From: Jason Humphries [REDACTED]
Sent: 26 September 2019 12:38
To: Zac Denton <Zac.Denton@arun.gov.uk>
Subject: Re: AB/39/19/PL - Query on application

LOCATION AND BLOCK PLANS
DATE: March 2017
SCALE: 1:1250 @ A3
JOB No. 1010
DRWG No. HS_000 Rev.

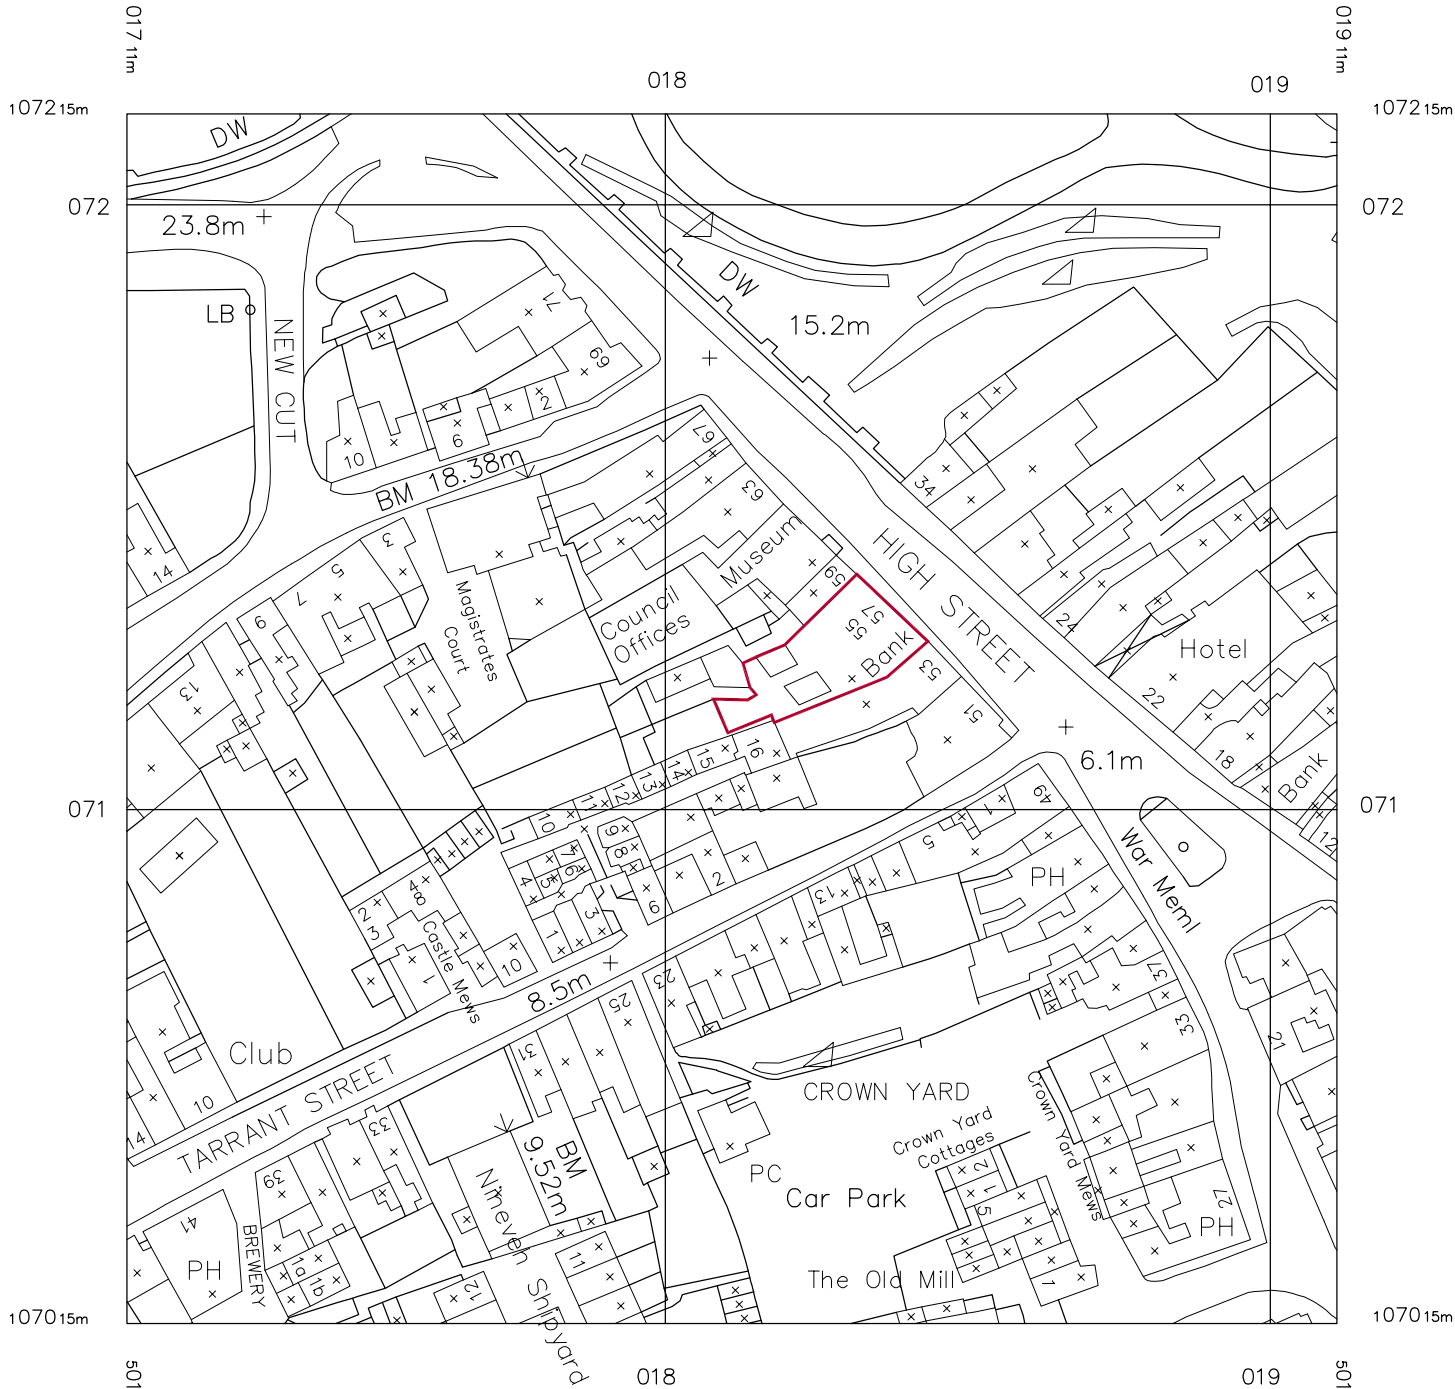
The area of land bordered by the red line on the block plan includes a residential flat, can you confirm that you are wishing to change the use of this to A2?

SCALE. 1:100 @ A3
JOB No. 1010
DRWG No. HS_S01 Rev.

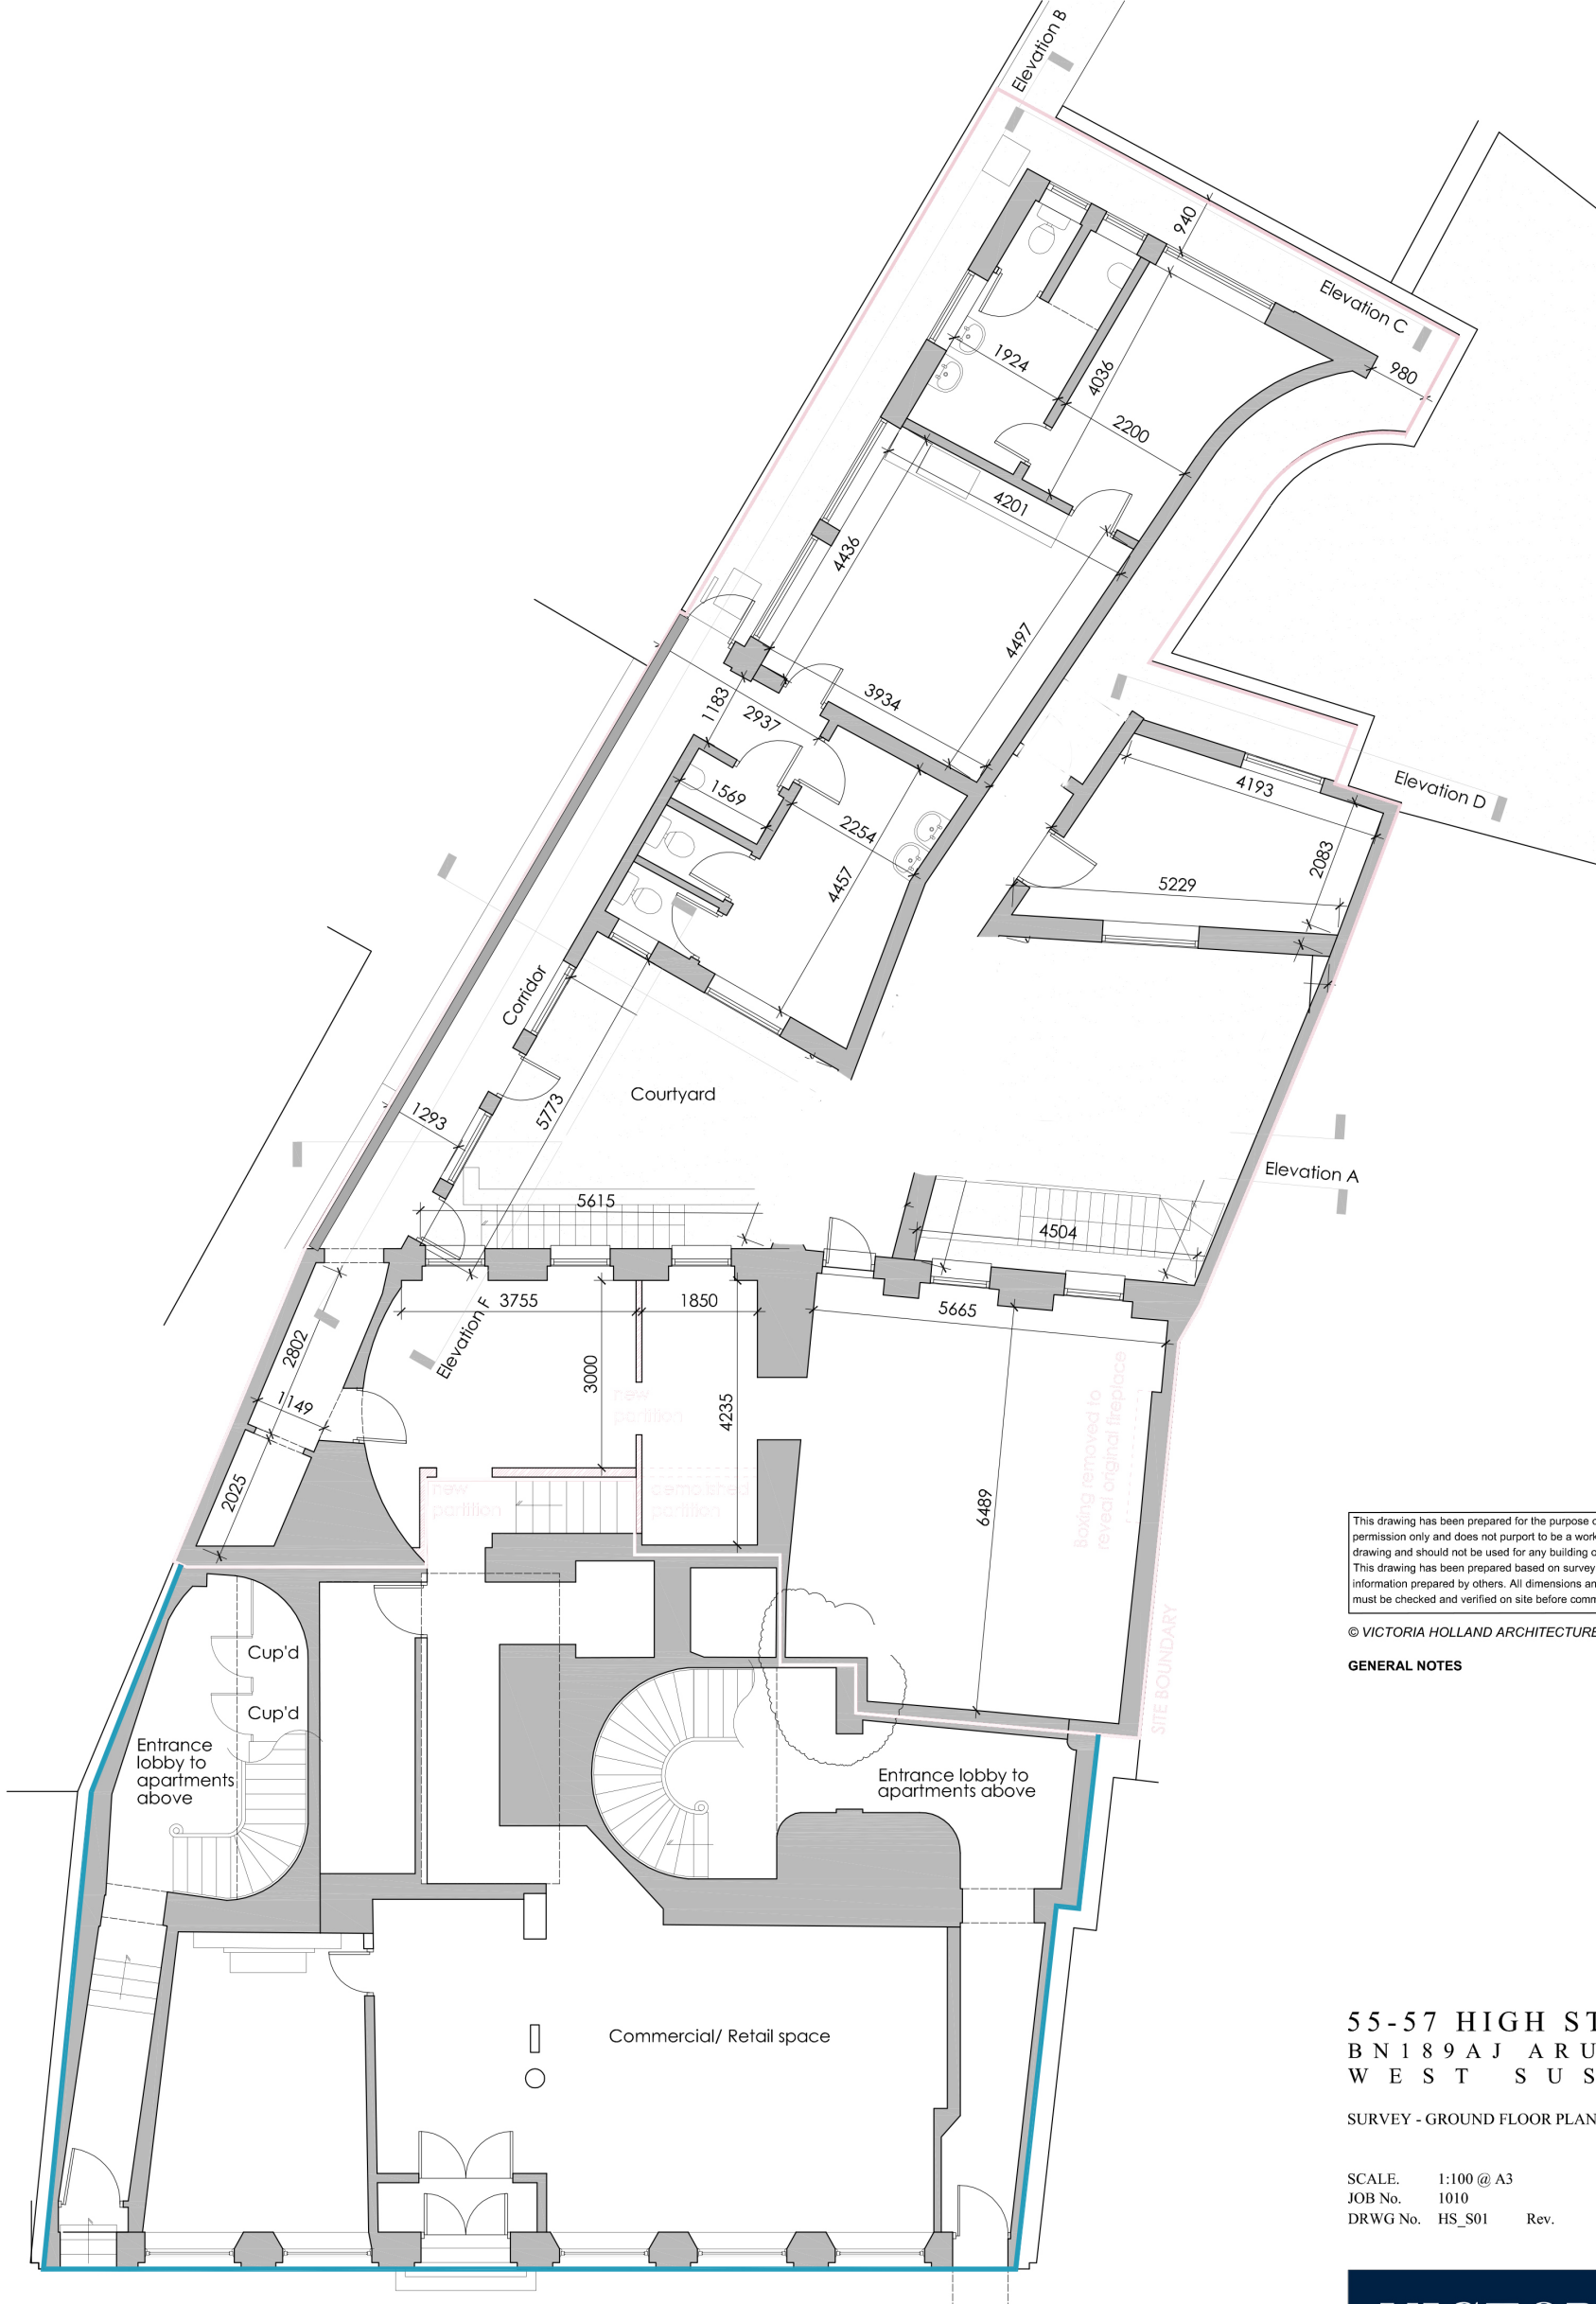
There are differences between the plans submitted, and what was approved under the previous application. Will the previously approved residential area in the South-Western corner of the site also form part of the change of use?

What is the proposed use of the outdoor courtyard area, does this remain residential?

It would appear on the proposed plan 'HS_S01', that it does not change from 'Studio flat'.

Per existing planning permission, it will be associated with the existing residential use.

Hi Zac – thank you for your email. I think your question is answered by my reply to your colleague Sian on 25th May – let me forward that to you and then perhaps get back to me if further clarification is required?
